April 24, 2023

**RE: Undi Commerce Park**

The responses below correlate to the numbered review comments on your letter dated April 27, 2022.

sheet
A1.2

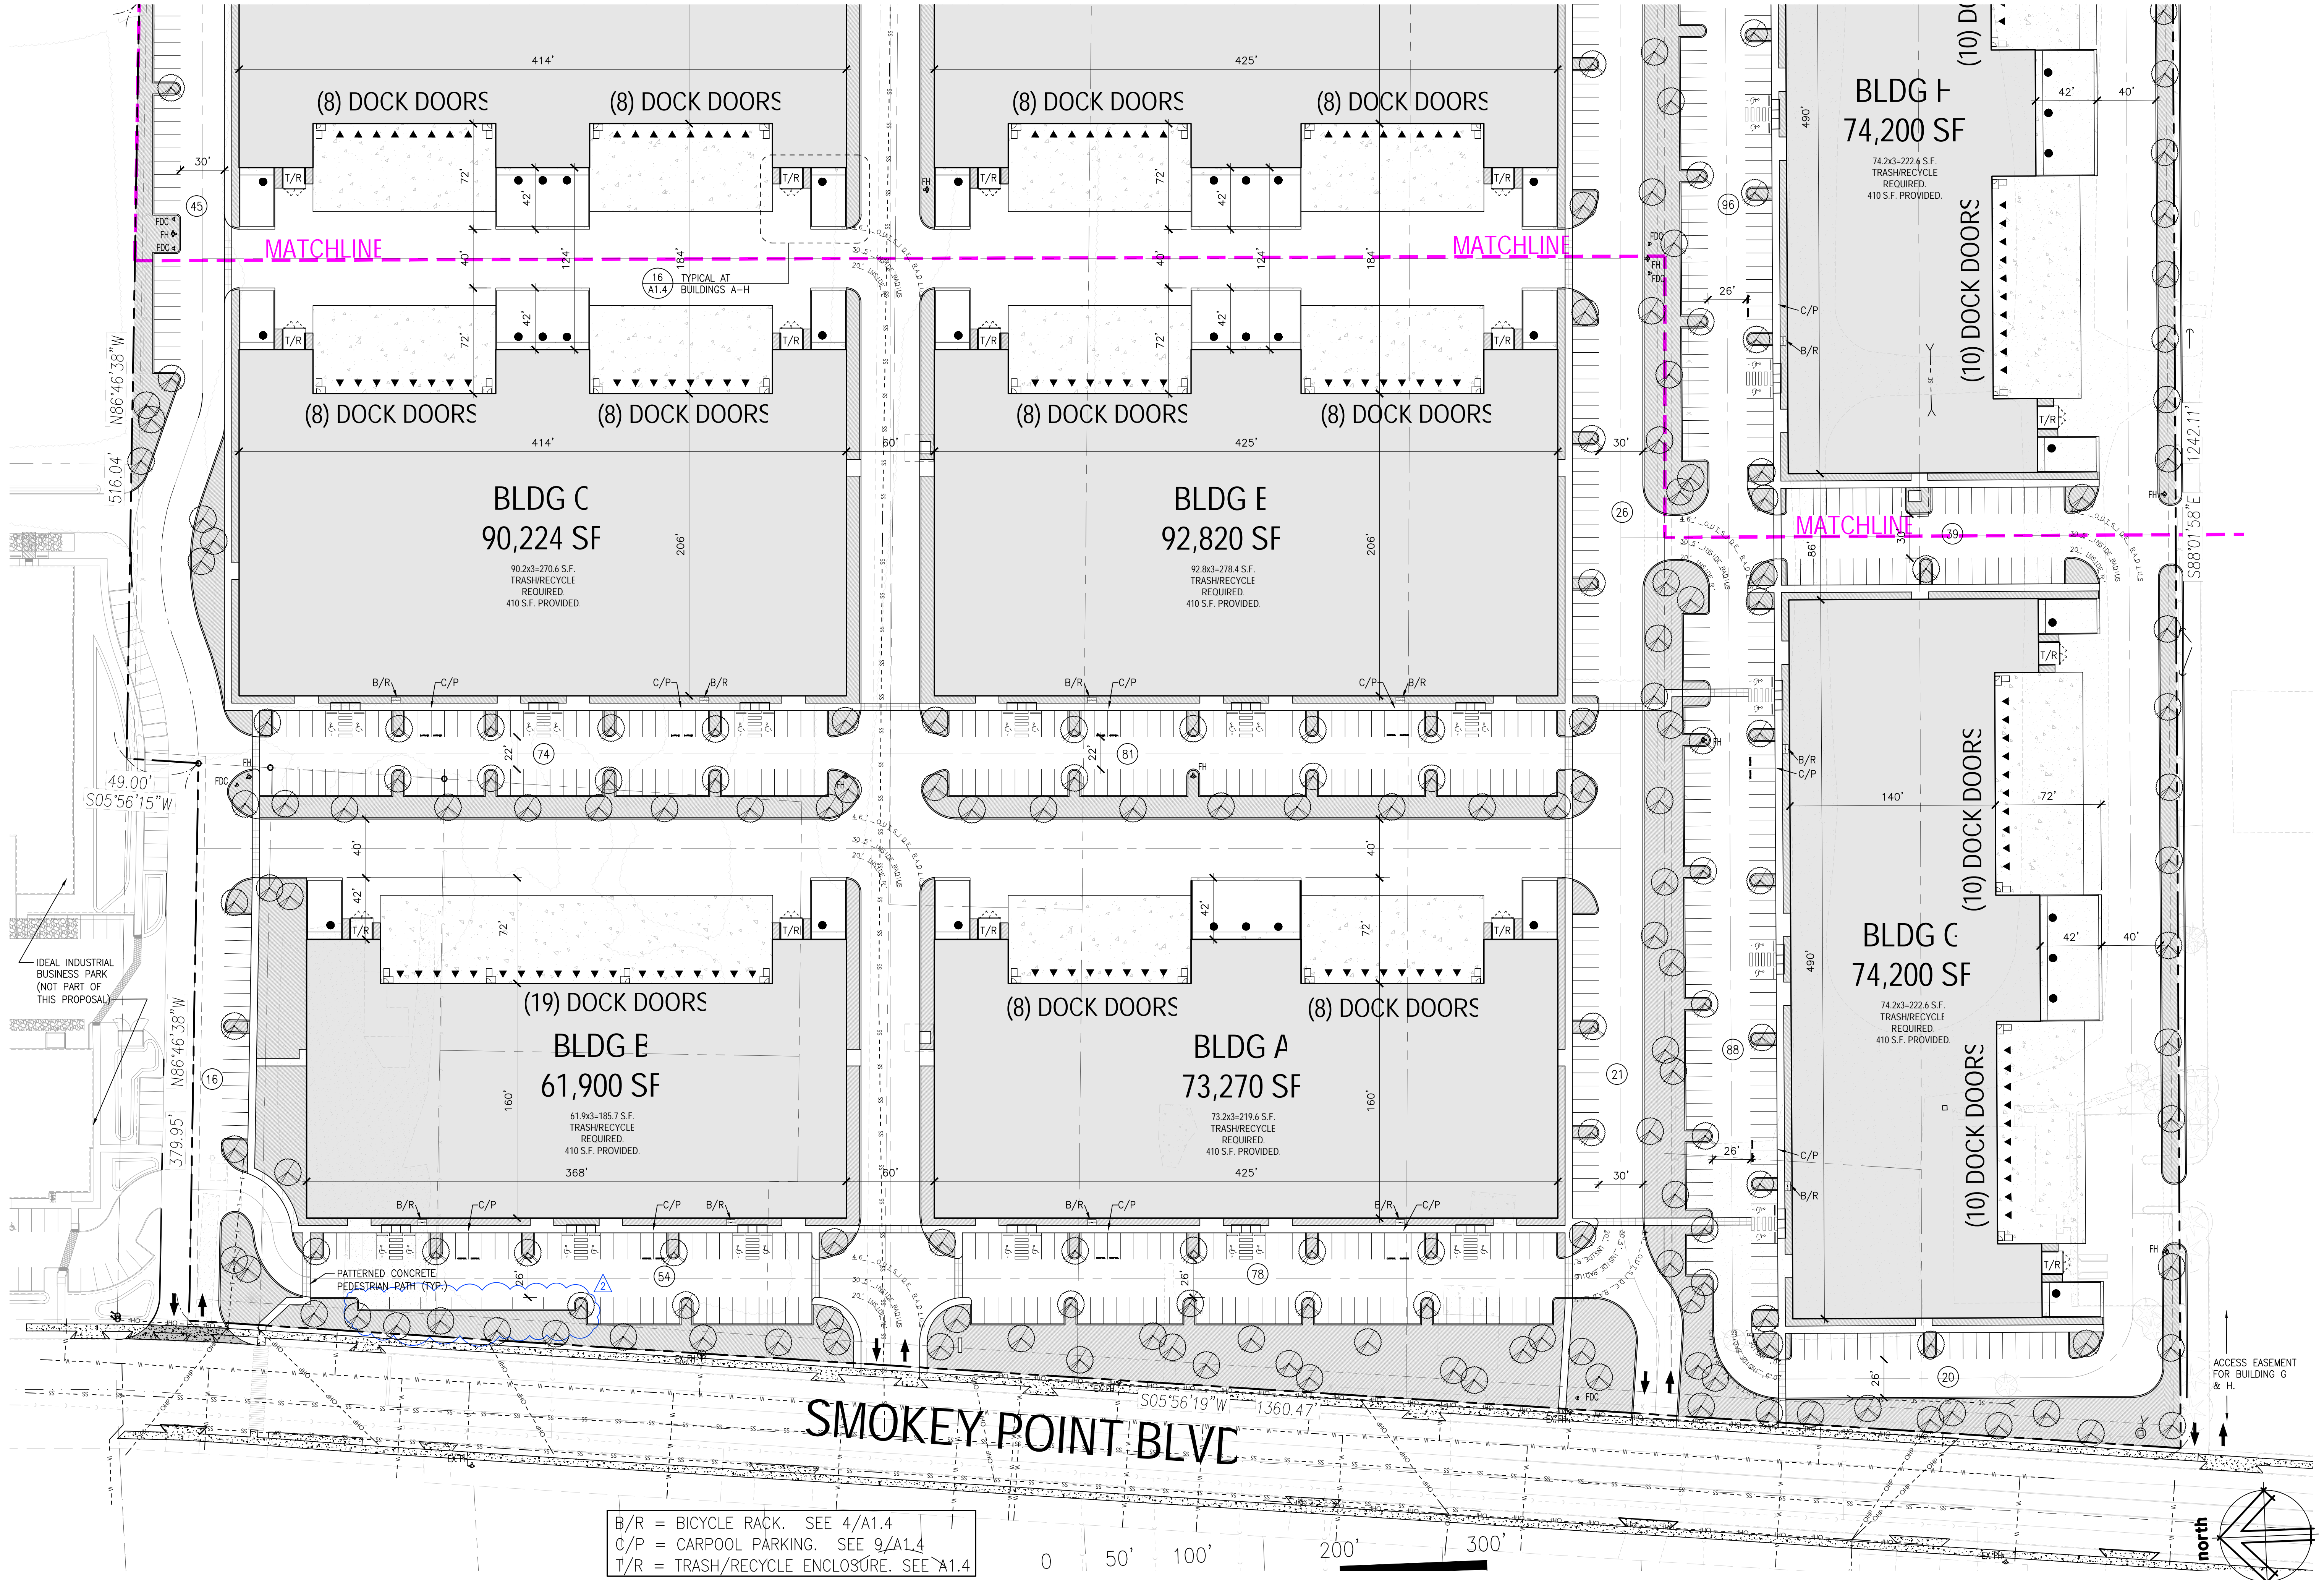
- 5a. Architectural sheets have been revised to 1"=50'-0" scale. The topographic survey sheets are 1"=40'-0" scale.
- 5b. Site plans have been revised to reflect (3) access points on the frontage abutting Smokey Point Boulevard as discussed with city Kacey Simon. See sheet A1.3

16 TRASH/RECYCLE ENCLOSURES
Scale: 1/4"=1'-0"

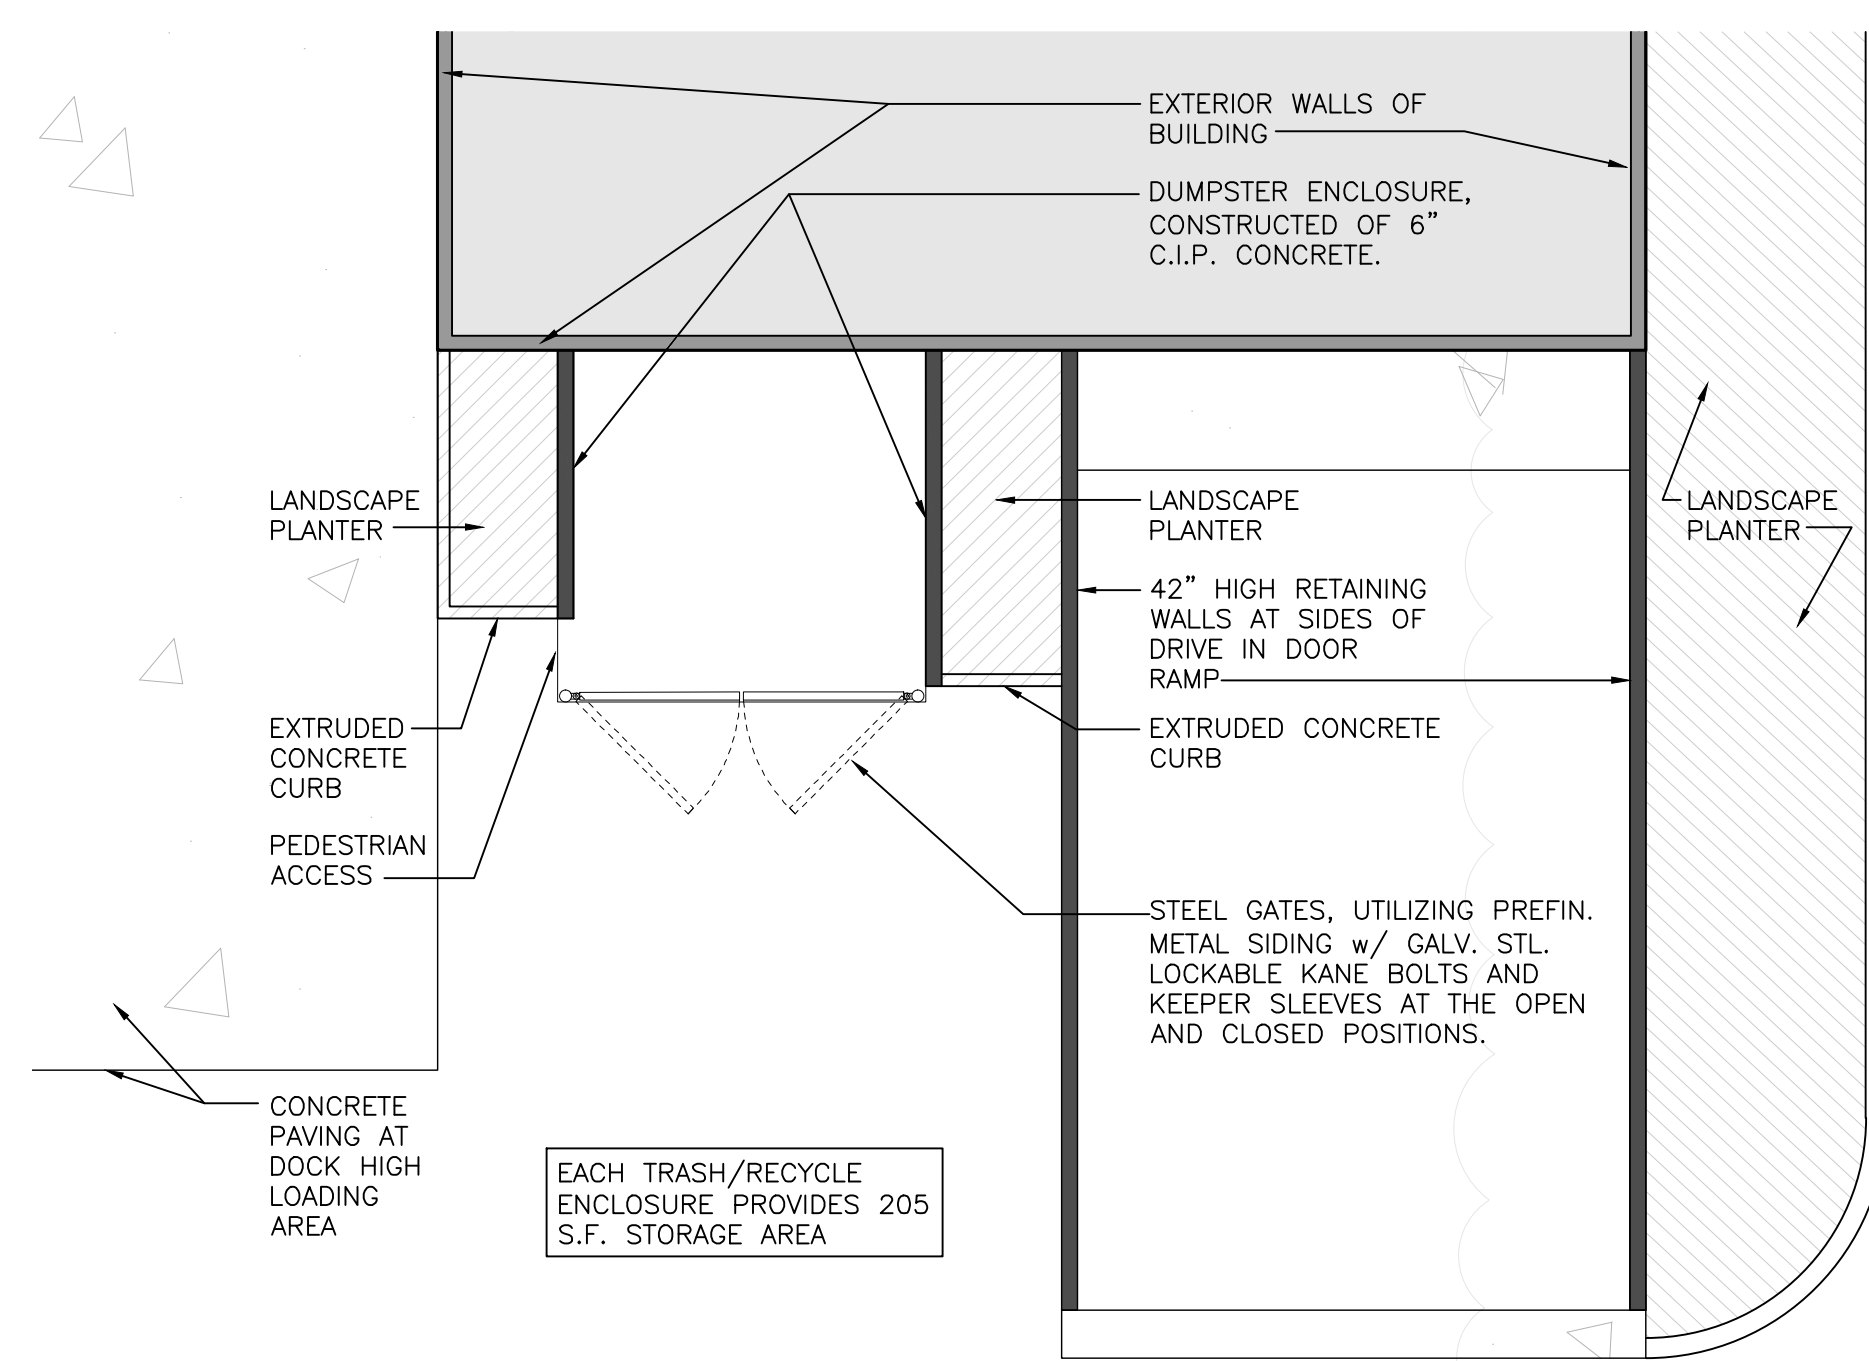
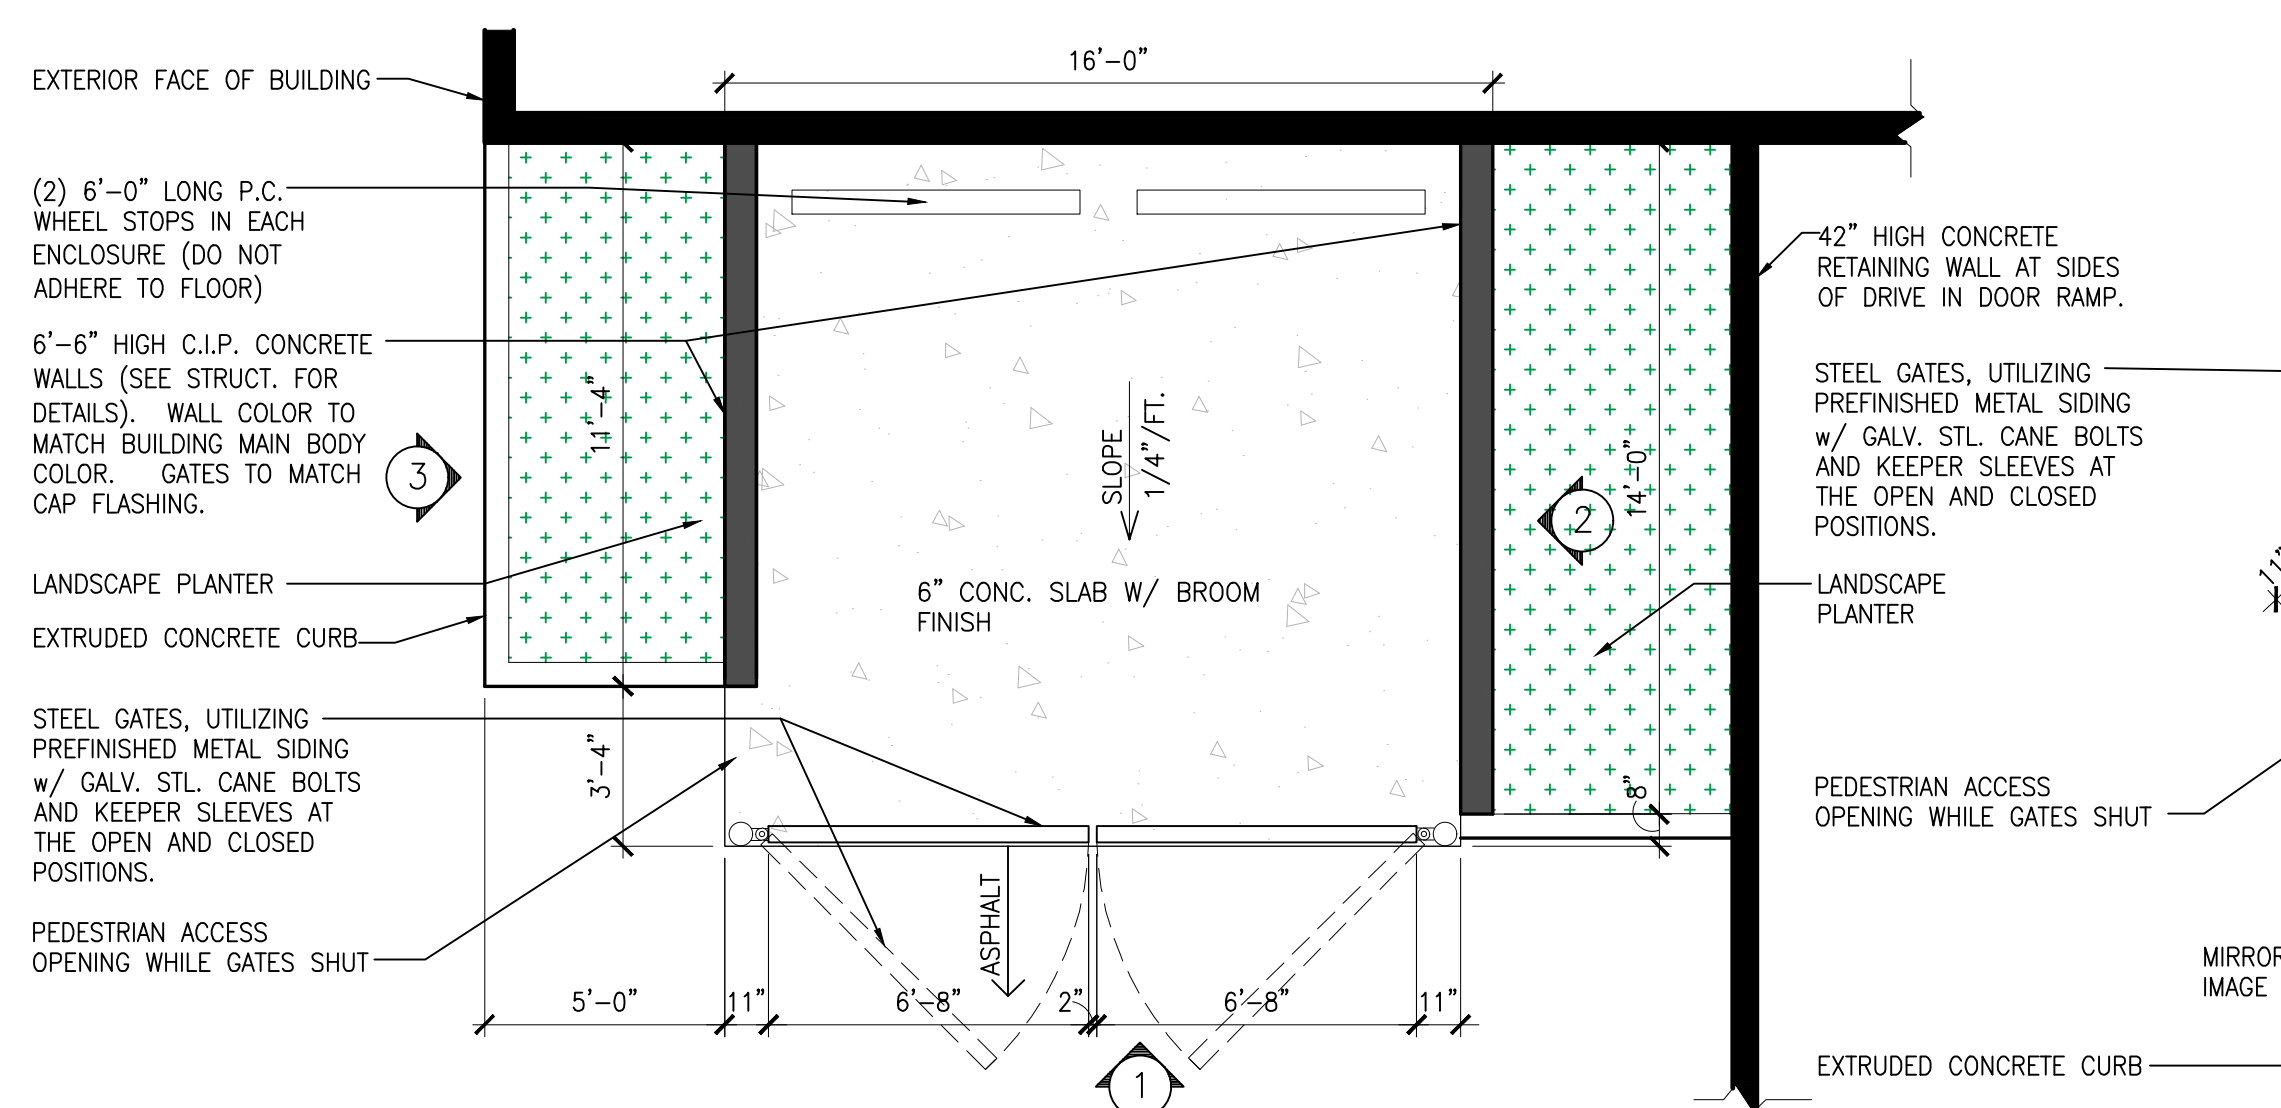
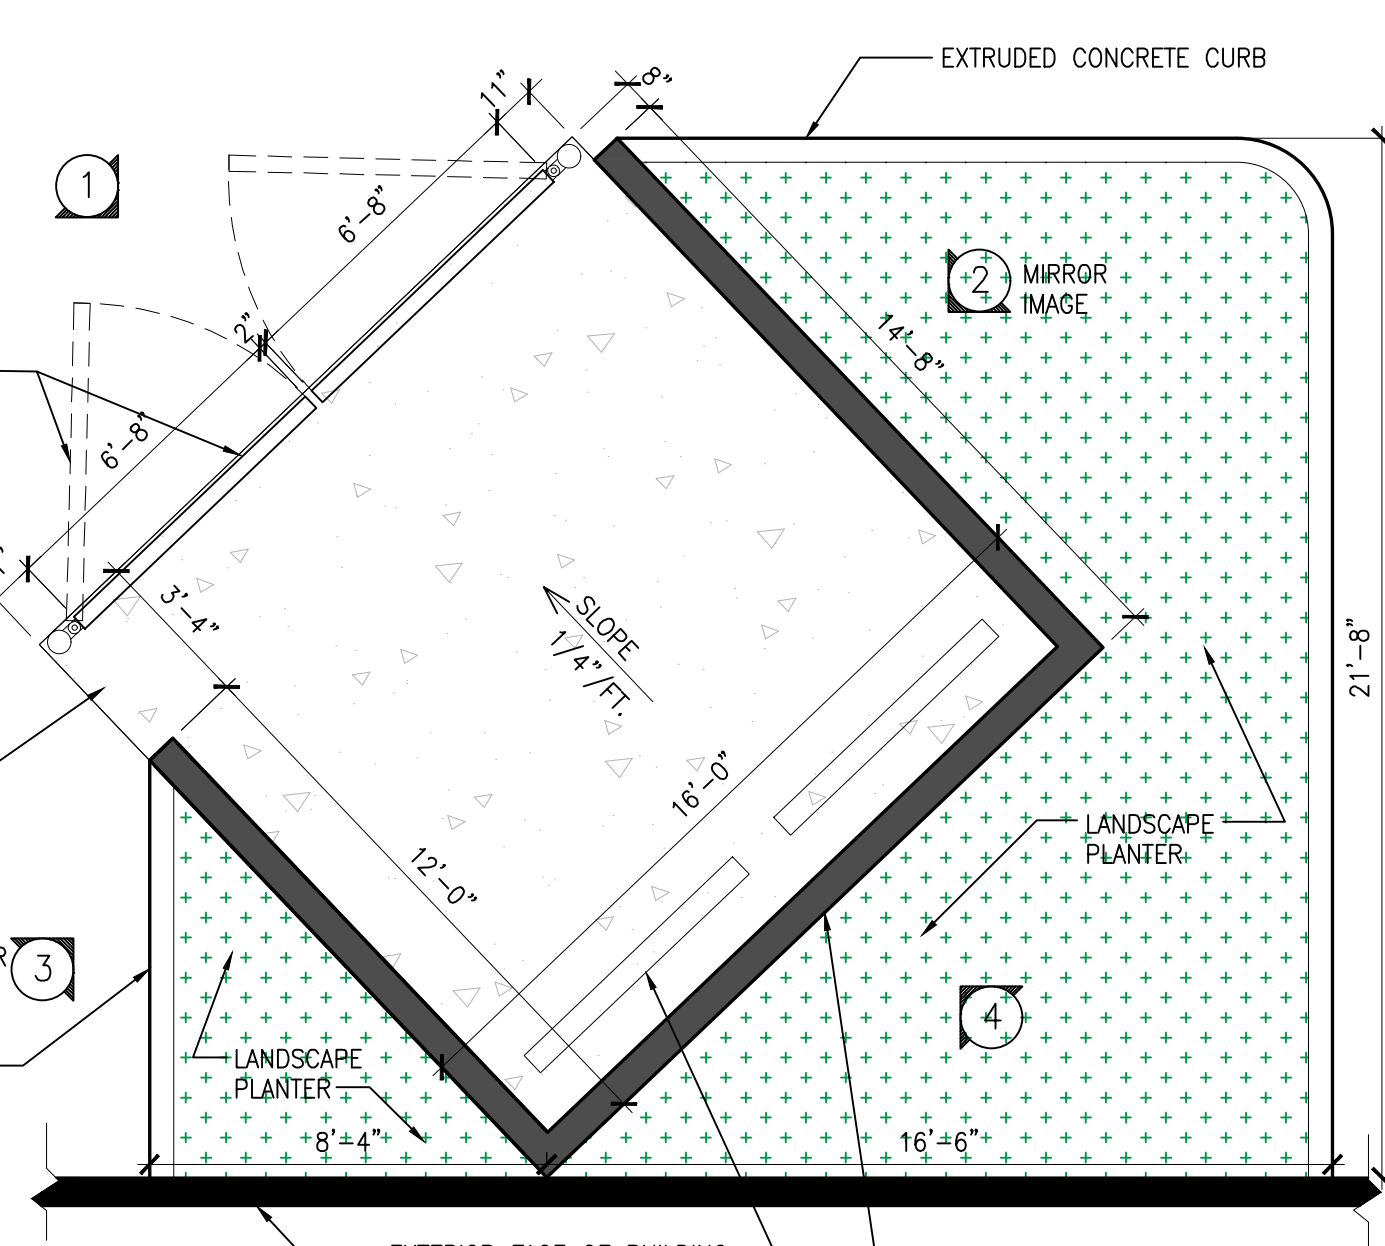
- 5c. Trash/recycle enclosures have been added to the site plans as requested. Required SF calculations are shown on each building. Provided SF is greater than required for all buildings. Landscaping has been provided around each and all enclosures are shielded from city streets and neighboring properties by perimeter landscaping. Enclosure walls are concrete complementary to the buildings. Details for enclosure, gates and wall elevations are shown on sheet A1.4.
